WEST SUSSEX COUNTY COUNCIL CONSULTATION

TO:	Arun District Council FAO: Ms M Tomalova
FROM:	WSCC - Highways Authority
DATE:	23 February 2021
LOCATION:	377-379 Chichester Road Bersted PO21 5AT
SUBJECT:	BE/7/21/PL Demolition of outbuilding & change of use of redundant shop to 3 No. two bedroom flats, associated parking & gardens. This site is in CIL Zone 4 (Zero Rated).
DATE OF SITE VISIT:	n/a
RECOMMENDATION:	Advice
S106 CONTRIBUTION TOTAL:	n/a

Drawing: Block and site layout plan- (1:200@A3)

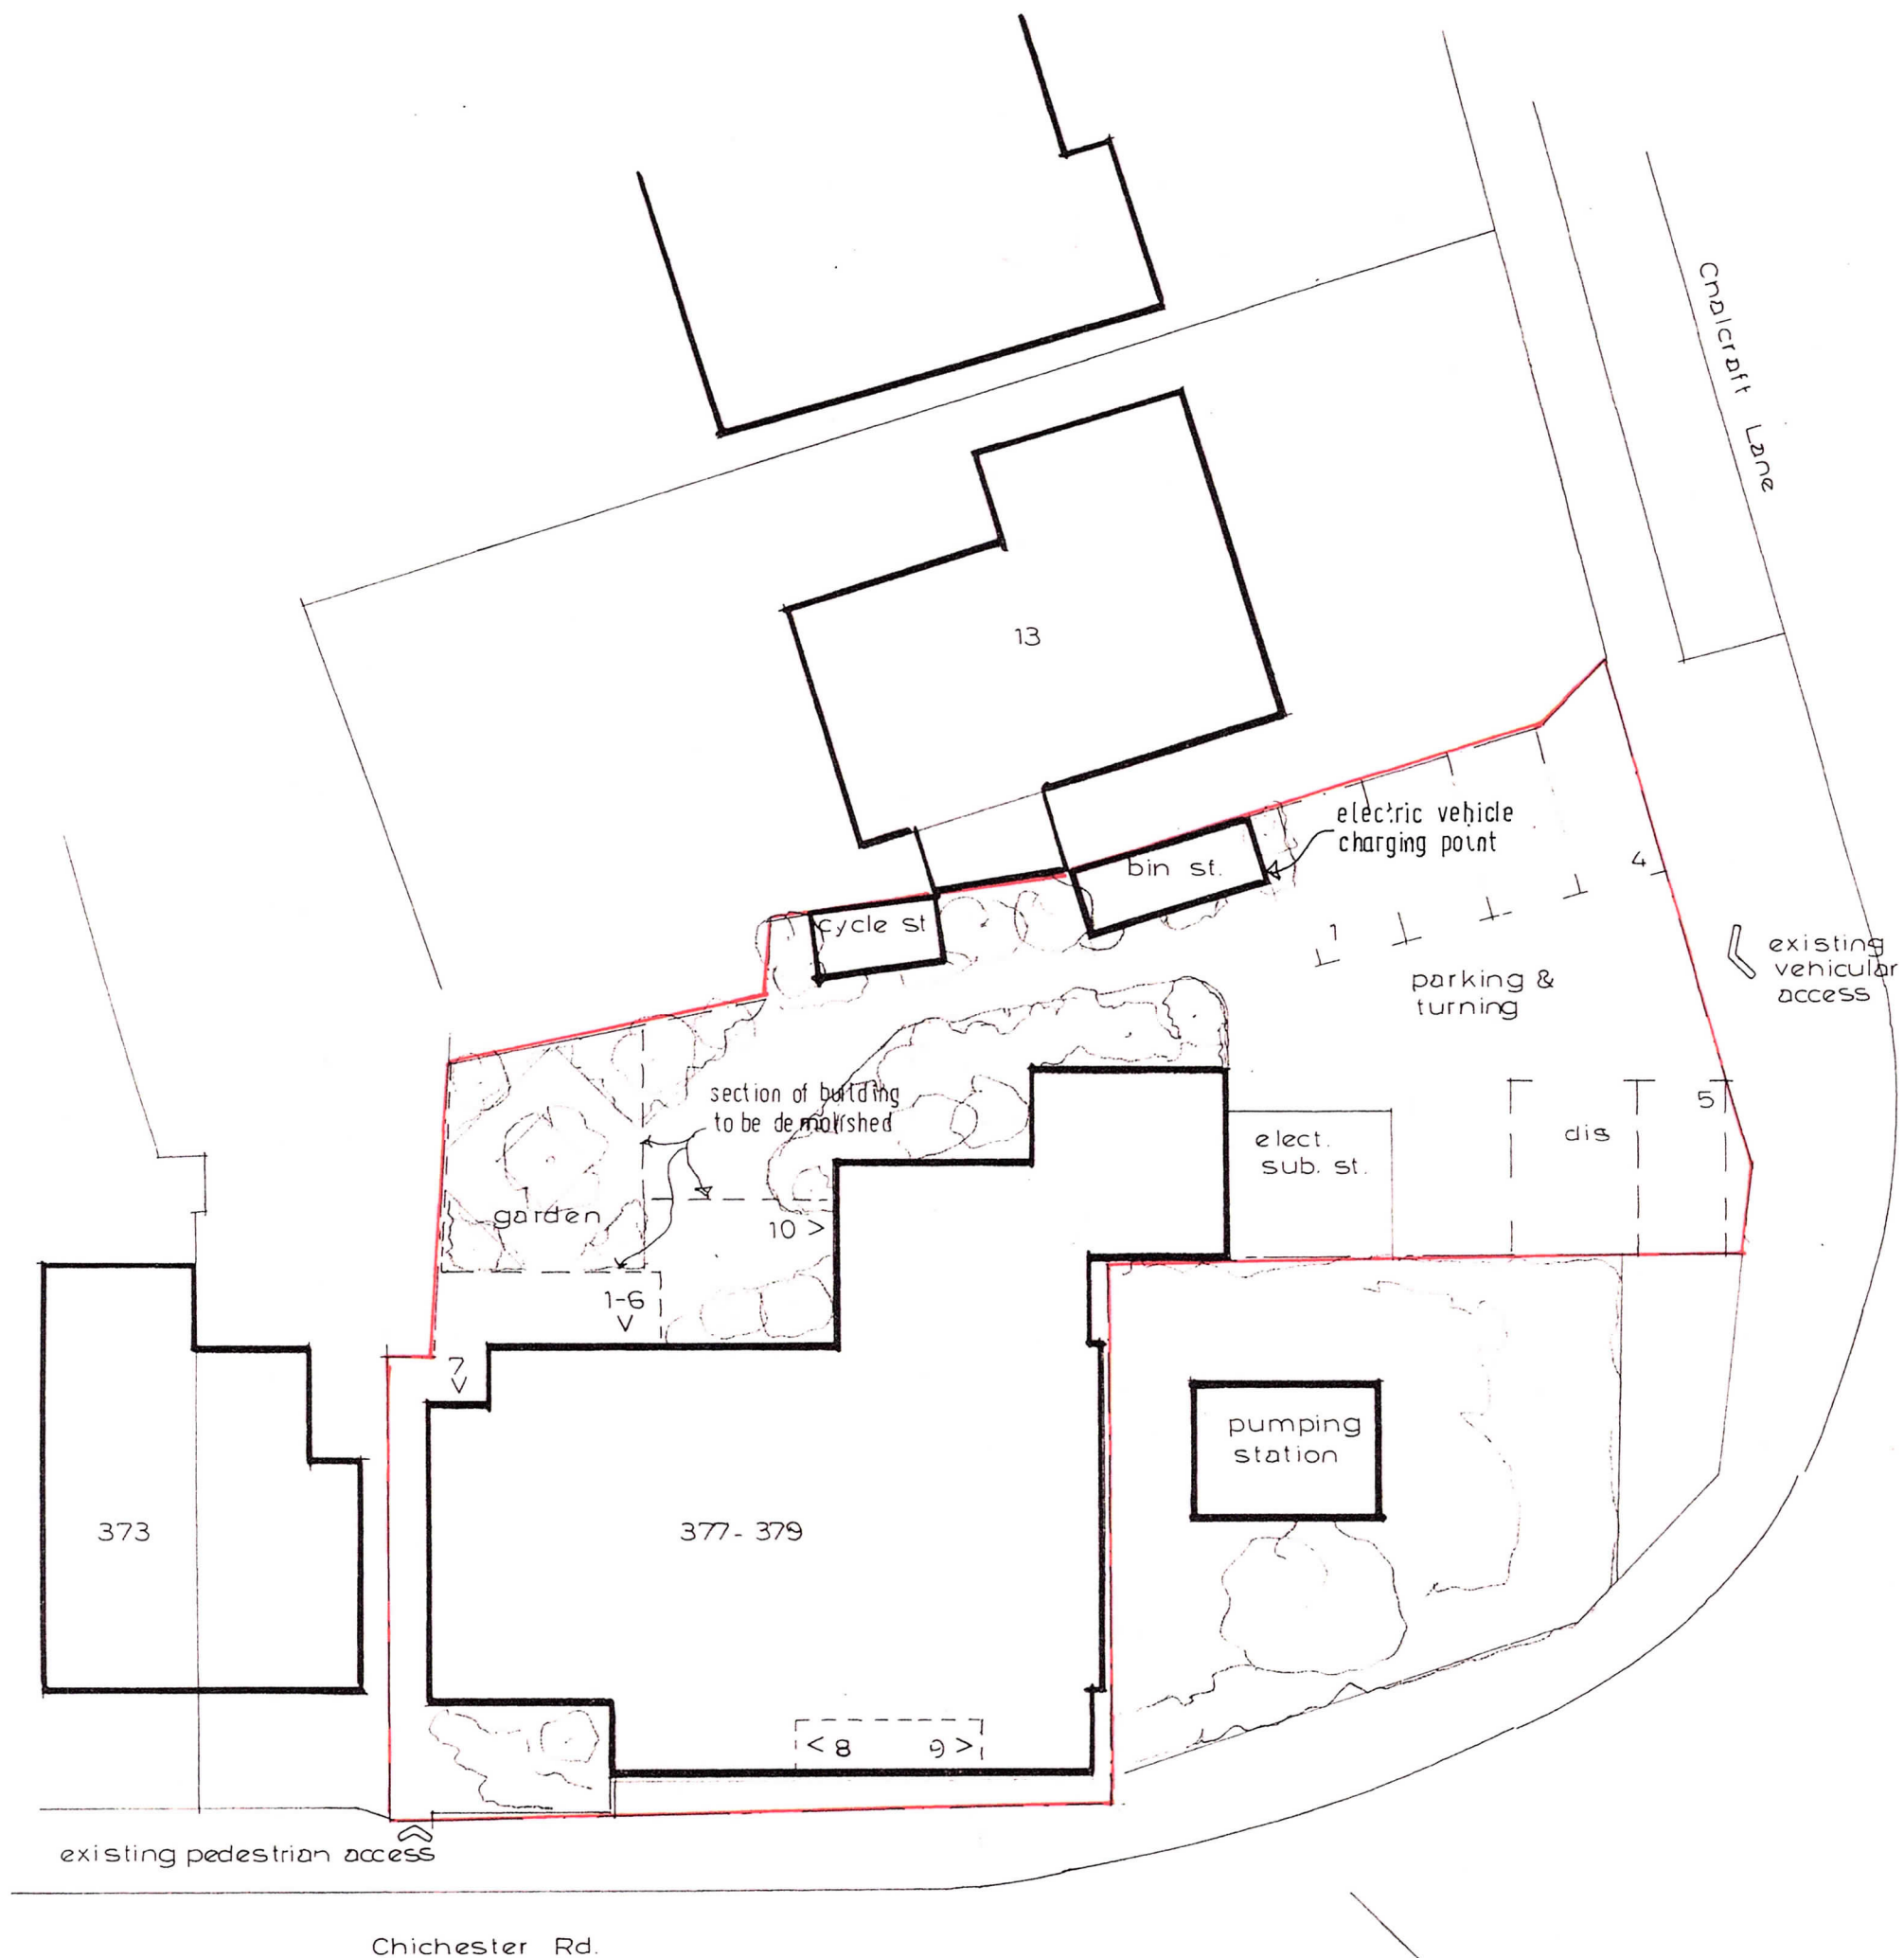
Onsite parking provision of 5 spaces is proposed to serve the site, 1 additional when compared to the existing parking arrangement. Under the WSCC Car Parking Standards, 2 car parking spaces per every converted flat may be provided. Whilst on-street car parking is limited in the immediate vicinity there are comprehensive parking restrictions prohibiting vehicles from parking in places that would be detriment to highway safety. Furthermore, the site has been operating with these parking arrangements for some time without any evidence of highway safety concern. We would not consider that highway safety would be detrimentally affected through the proposed car parking

provision. The Planning Authority may wish to consider the potential impacts of this development on on-street car parking. Electric Vehicle (EV) charging point has been demonstrated on the proposed plan and details of this can be secured via planning condition.

Cycle storage accommodating up to 10 bicycles has been demonstrated on a plan which promotes the use of sustainable transport methods.

No part of the development shall be first occupied until the car parking has been constructed in accordance with the approved Block and site layout plan. These spaces shall thereafter be retained at all times for their designated purpose.

No part of the development shall be first occupied until covered and secure cycle parking spaces have been provided in accordance with the approved Block and site layout plan.

No part of the development shall be first occupied until the electric vehicle charging space(s) have been provided in accordance with the approved Block and site layout plan.
